Final Report - Corrections Required **Application No. DEPN-24-0160**

Description : Multi-family development with 170 rental duplex units on one development lot. Also a request for alternate landscape compliance related to placement of streamside overly and property boundary buffer plantings, and to be allowed to provide 9.4% active open space where 10% is required.

Address : 2210 Old Ranch RD Colorado Springs CO 80920

Document Filename : 197354_GeoHaz_10.14.24.pdf

## SITE PLAN

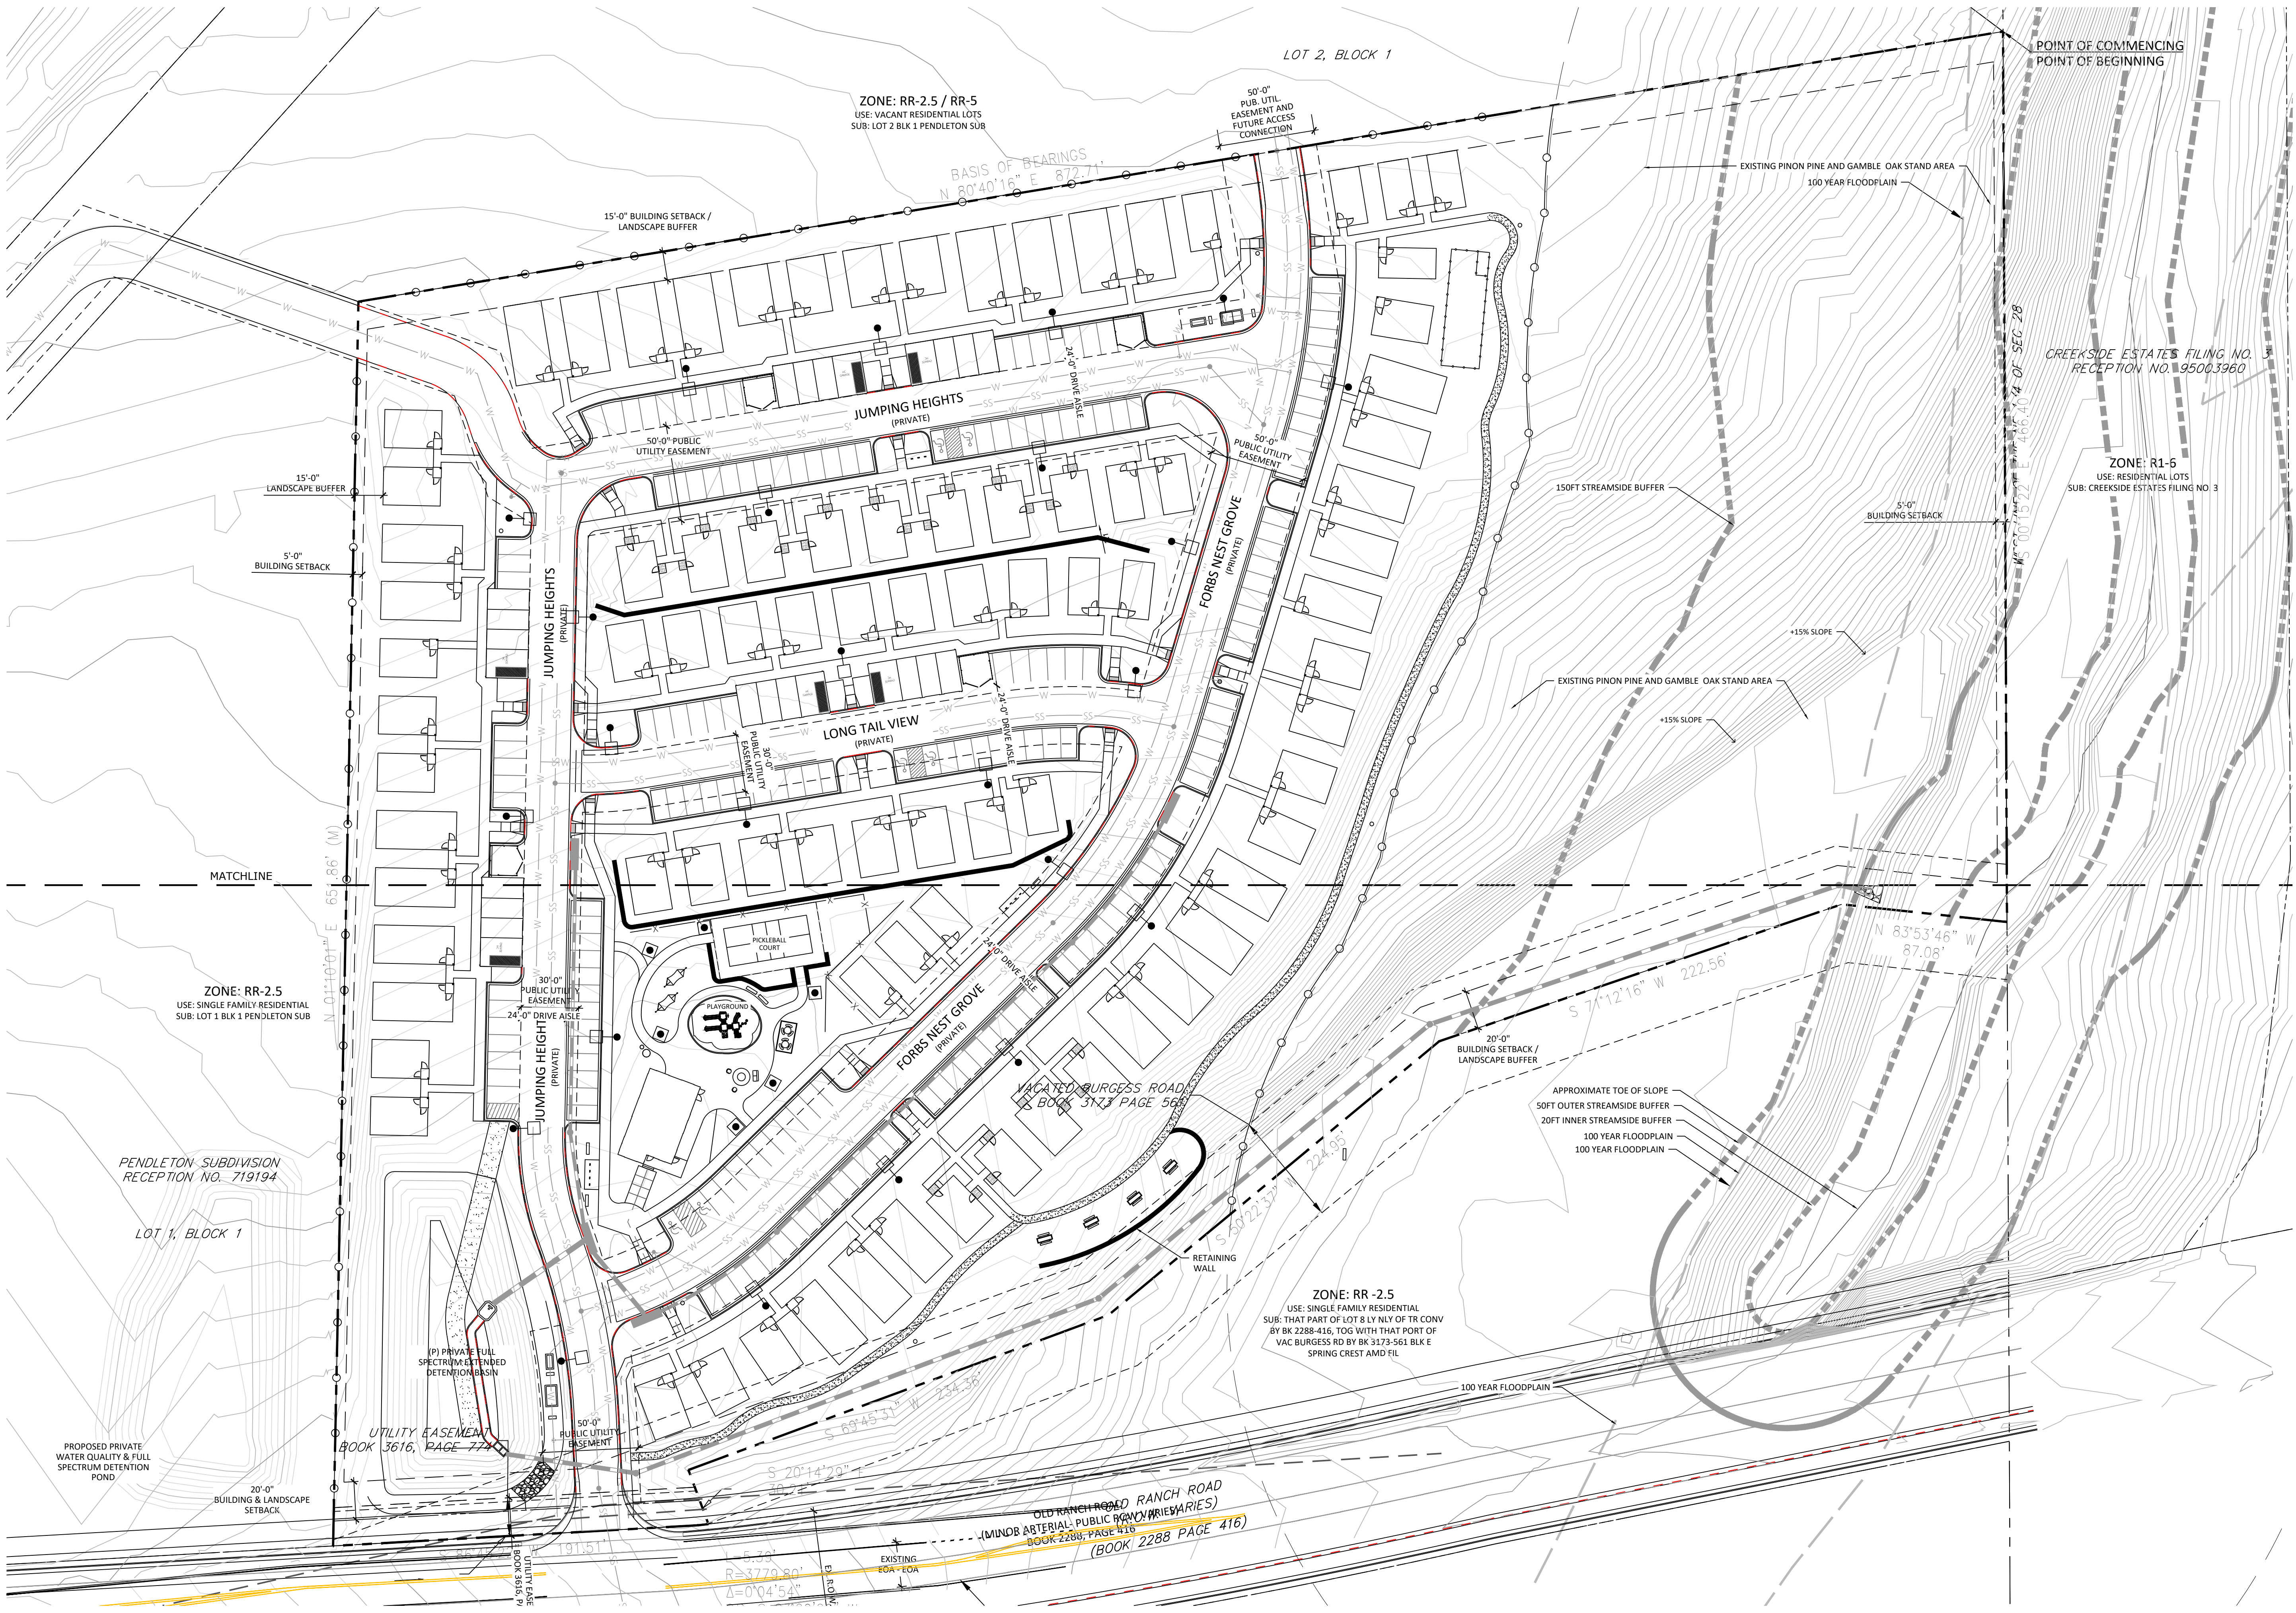
Comment ID	Reviewer : Department	Review Comments
		<p>A PDR submittal is now acceptable instead of an FDR submittal in support of a Final Plat (FP). The PDR must be approved before the FP can be recorded.</p> <p>An FDR may still be submitted in support of DP or FP approval if final design information is available at the time of the DP or FP submittal. FDR Addendums are no longer accepted. All required final calculations must be included in the FDR prior to FDR approval.</p> <p>FDR approval is still a prerequisite for Construction Drawing (CD) approval (e.g., GEC Plan, Drainage Plan/Profile, PCM Plan, etc.).</p> <p>Master Development Drainage Plans (MDDPs) are no longer required for DPs with 10 or more acres of earth disturbance proposed.</p> <p>Please see SWENT's website for updated checklists: https://coloradosprings.gov/stormwater-enterprise/page/stormwater-review</p>
50	Jonathan Scherer : City Engineering - SWENT	It appears that a portion of the floodway is on the Site, revise floodplain statement too.

51	Jonathan Scherer : City Engineering - SWENT	The Four Step Process and detention requirements must be met for this site, as disturbance is greater than 1 acre. Show provisions for WQ/Detention or provide a note on the cover sheet stating the name and location of the existing facility that provides water quality and detention for the site. The note must include the full FDR name that designed the PCM, who prepared that report, and the approval date of the report. If this Site is a redevelopment, detention may not be required if the downstream drainage system is shown to have capacity for the proposed developed flow.
52	Jonathan Scherer : City Engineering - SWENT	This development is adjacent to Kettle Creek. Per the DPBS, stream improvements may be required. Please reach out to SWENT to determine if channel improvements are required.
53	Jonathan Scherer : City Engineering - SWENT	A portion of the development appears to be within the 100-year floodplain. Please coordinate with the PPRBC floodplain administrator on any requirements needed for work within the floodplain. Please include all related correspondence and/or approval from floodplain administrator in the PDR/FDR for this site.
